Application number: 2025/93140	
What is the application for?:	Installation of replacement shop front and roller shutter (within a Conservation
Address of the site or building:	Kami Healthcare Ltd, 8, Market Place, Birstall, Batley, WF17 9EL
Postcode:	WF17 9EL

Proposed Front Elevation with Roller Shutter

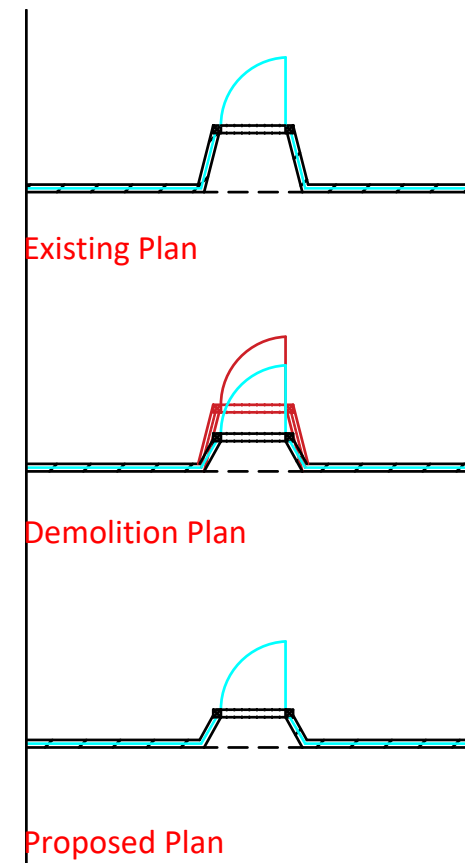
Type of comment: An objection	
Do you wish your comments to be published on the website anonymously?	<input type="checkbox"/> Yes
<p>I wish to object to the above planning application for the installation of a replacement shopfront and roller shutter within a designated Conservation Area.</p> <p>The proposed development would have a detrimental impact on the character and appearance of the Conservation Area. Traditional shopfronts contribute significantly to the historic and architectural interest of the area, and the introduction of a modern replacement shopfront and roller shutter would appear visually intrusive and out of keeping with the surrounding historic buildings.</p> <p>In particular, external roller shutters are generally inappropriate in Conservation Areas as they create a closed and unattractive street frontage, especially outside business hours. This would harm the visual amenity of the area and undermine the established historic streetscape.</p> <p>National and local planning policies place strong emphasis on preserving or enhancing the character and appearance of Conservation Areas. In my view, the proposal fails to meet these requirements and does not demonstrate sufficient consideration of heritage impact or sympathetic design.</p> <p>For these reasons, I respectfully request that the application be refused, or that the applicant be required to submit a revised scheme that better reflects the traditional design, materials, and detailing appropriate to a Conservation Area.</p>
